From: Garry Mount [REDACTED]
Sent: 09 October 2014 16:58
To: Janice Chapman
Subject: Quince cottage - BN/32/14/HH
Attachments: 2014-26-03 Site plan-Layout1.pdf; Quince Cottage - Sketches.pdf

Re: Quince Cottage, Church Lane, Barnham.
Your ref: BN/32/14/HH

Roof Plan

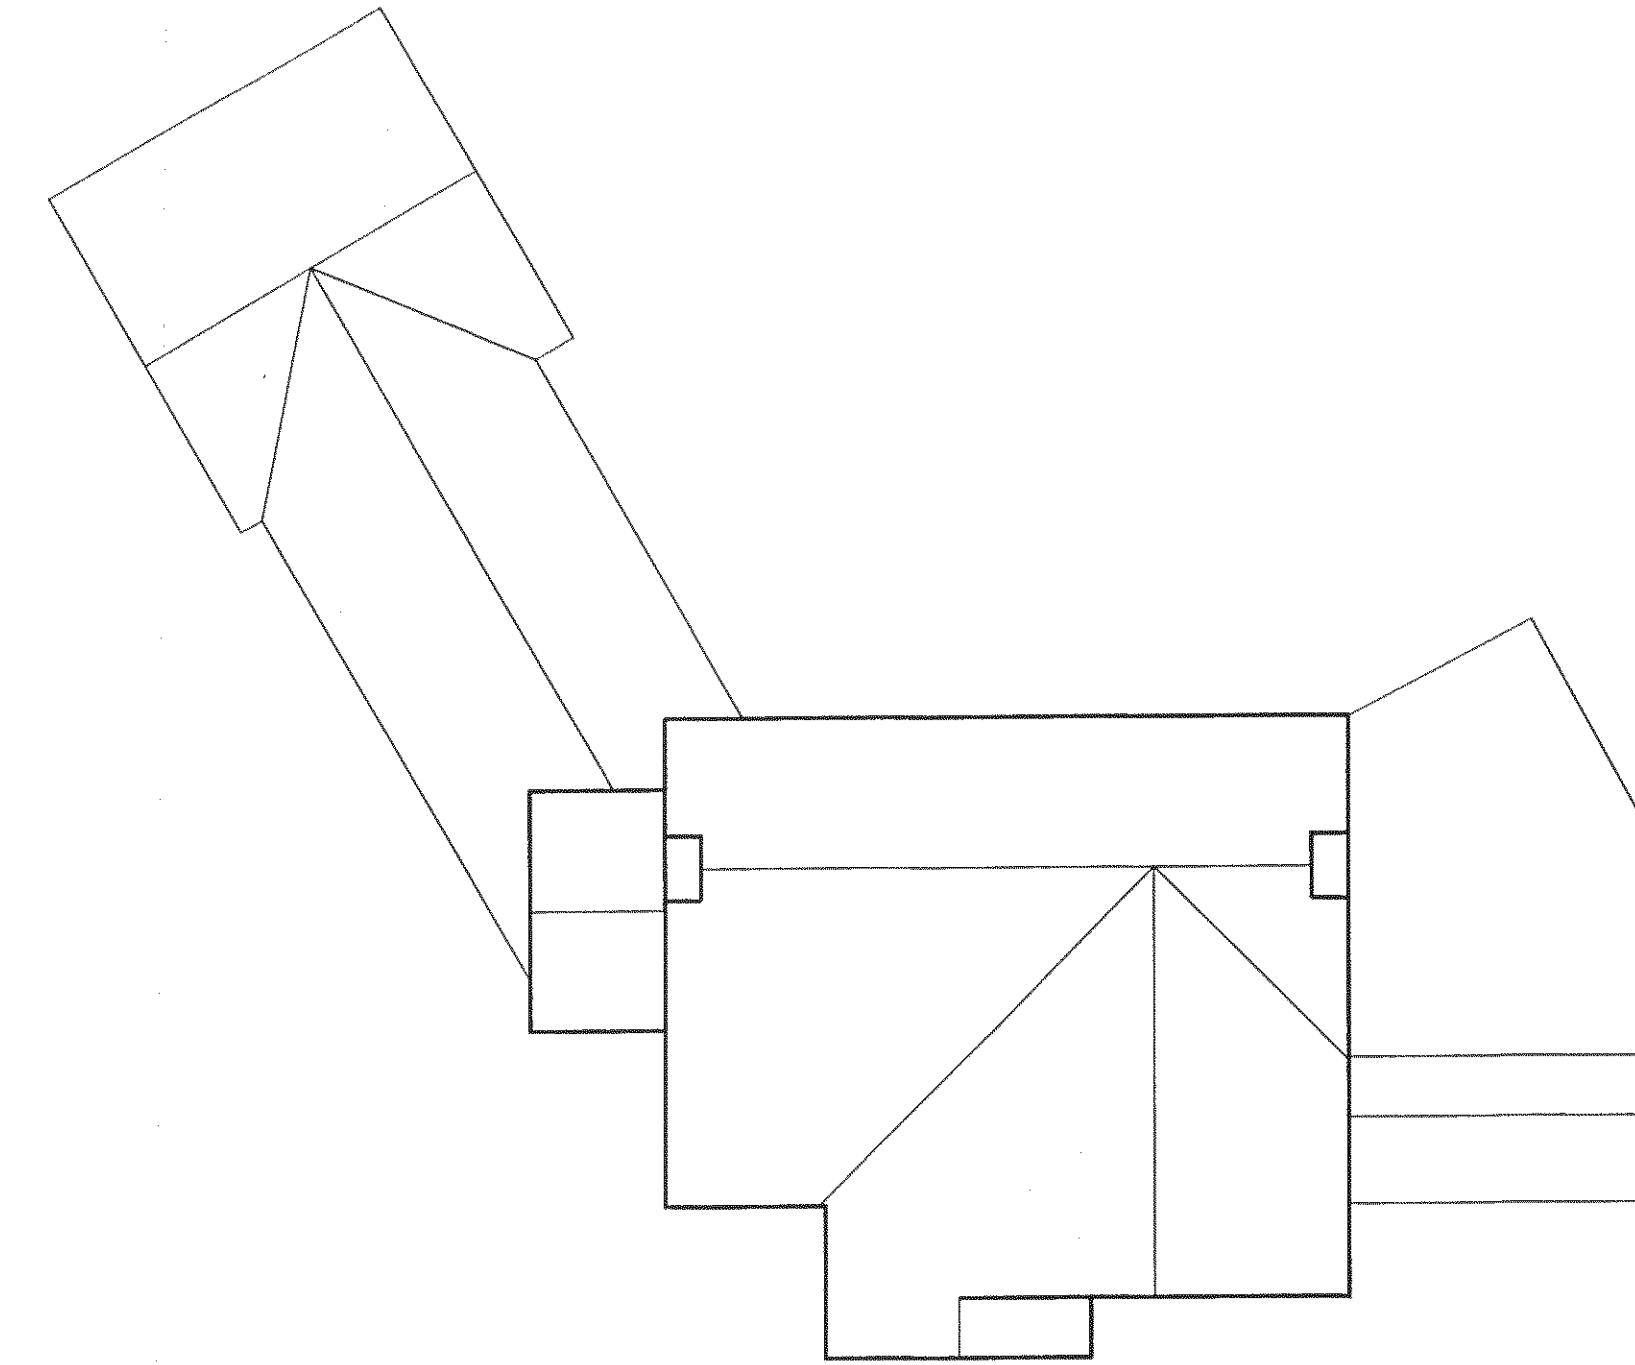
With reference to the extension to front elevation, I don't agree with Mr Vick's comment that the elevation would be unbalanced. This is not an unusual roof form, with a gable projecting from one end of a pitched roof, although not symmetrical it is a well proportioned and balances elevation. The style of the proposal is appropriate and the extension would enhance the appearance of the cottage. Currently there is a large expanse of tiled roof on the front elevation, broken up only by the projecting gable of the porch.

My original brief was to form a first floor extension over the existing single storey flat roof extension to the west elevation. Due to the orientation of the building and the boundary position the rear section of wall to the west elevation has been constructed at approximately 45 degrees to the main house. This makes it very difficult to design an extension over this area with a pitched roof. I have attached my initial sketches showing an extension over this area. I'm sure you would agree, the north elevation may be acceptable but the south and west elevations would not be.

We feel that current proposal is in keeping with the original cottage and enhances the front elevation.
